SSD 7968 – ORAN PARK SCHOOLS – Environmental Impact Statement

ATTACHMENT A

SSD 7968 ORAN PARK SCHOOLS

EROSION AND SEDIMENT CONTROL DETAILS

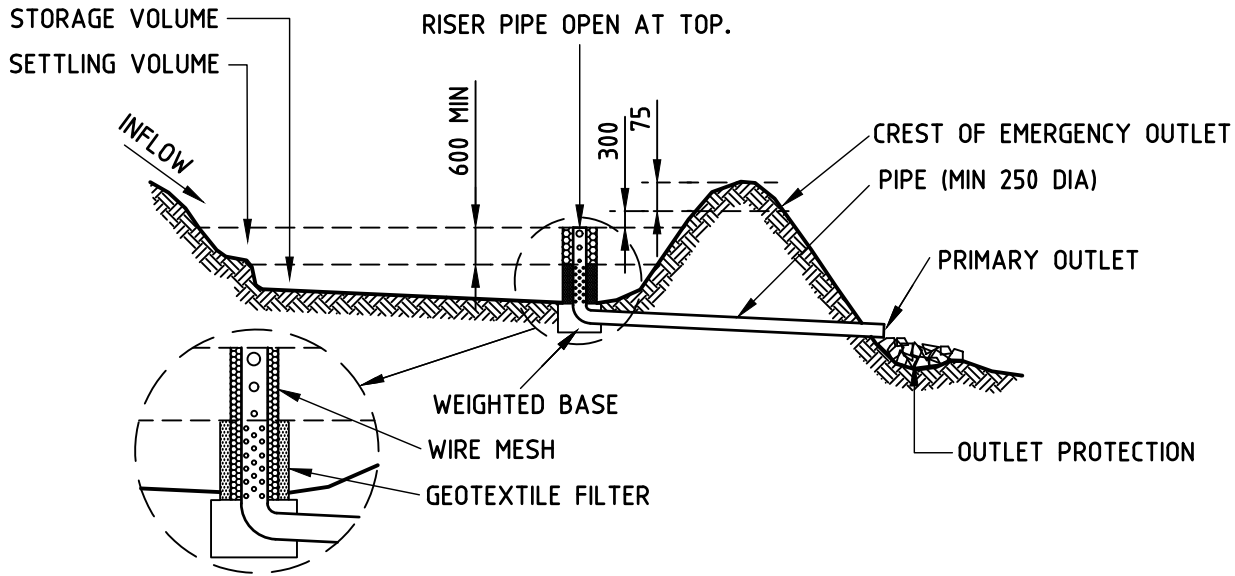
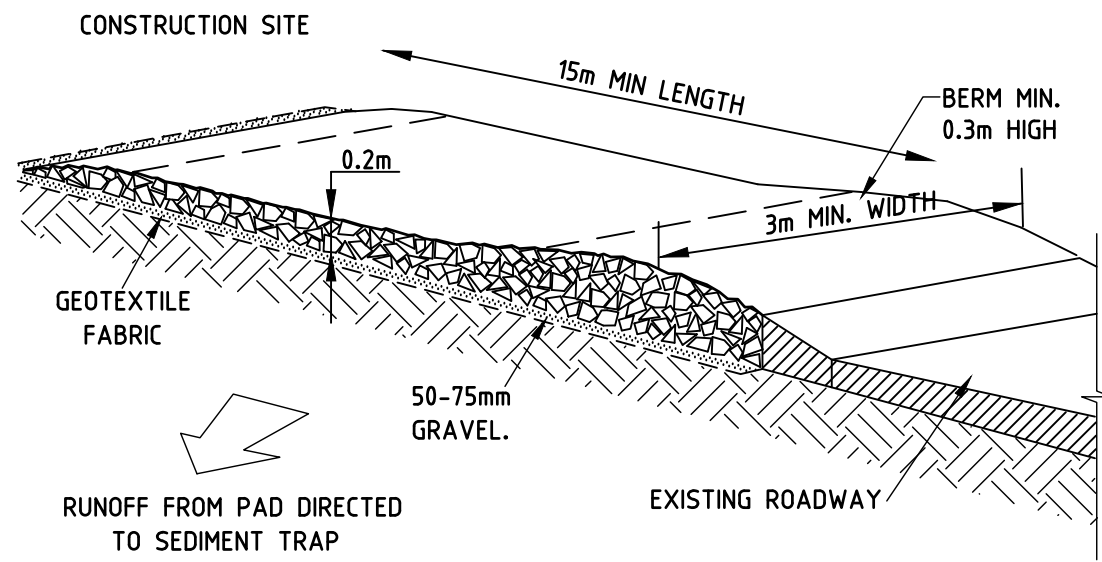
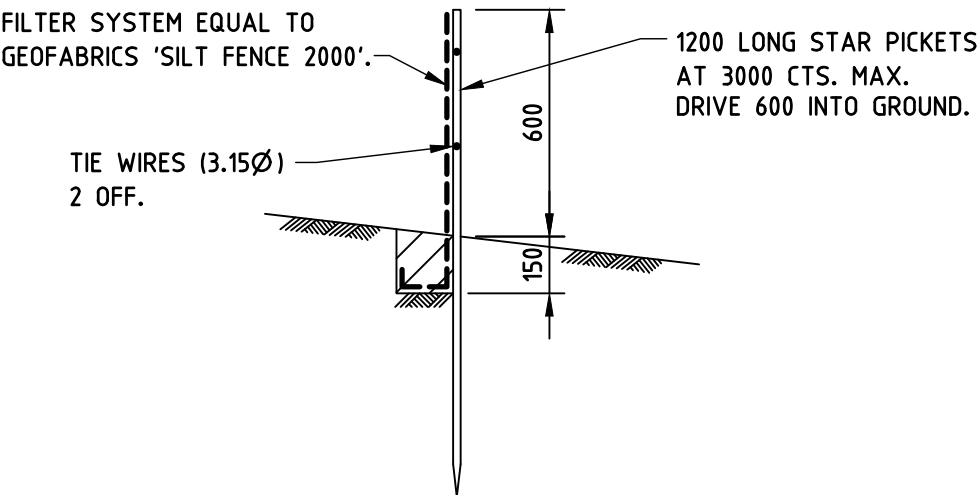
Managing Urban Stormwater Soils and Construction, 4th Edition published by Landcom (the so-called 'Blue Book') provides guidance material for achieving effective sediment control on construction sites. The proponent should implement all such feasible and reasonable measures as may be necessary to prevent water pollution in the course of developing the site.

The EPA emphasises the importance of –

- (a) not commencing demolition, construction and construction-related activities until appropriate and effective sediment controls are in place, and
- (b) daily inspection of sediment controls which is fundamental to ensuring timely maintenance and repair of those controls.
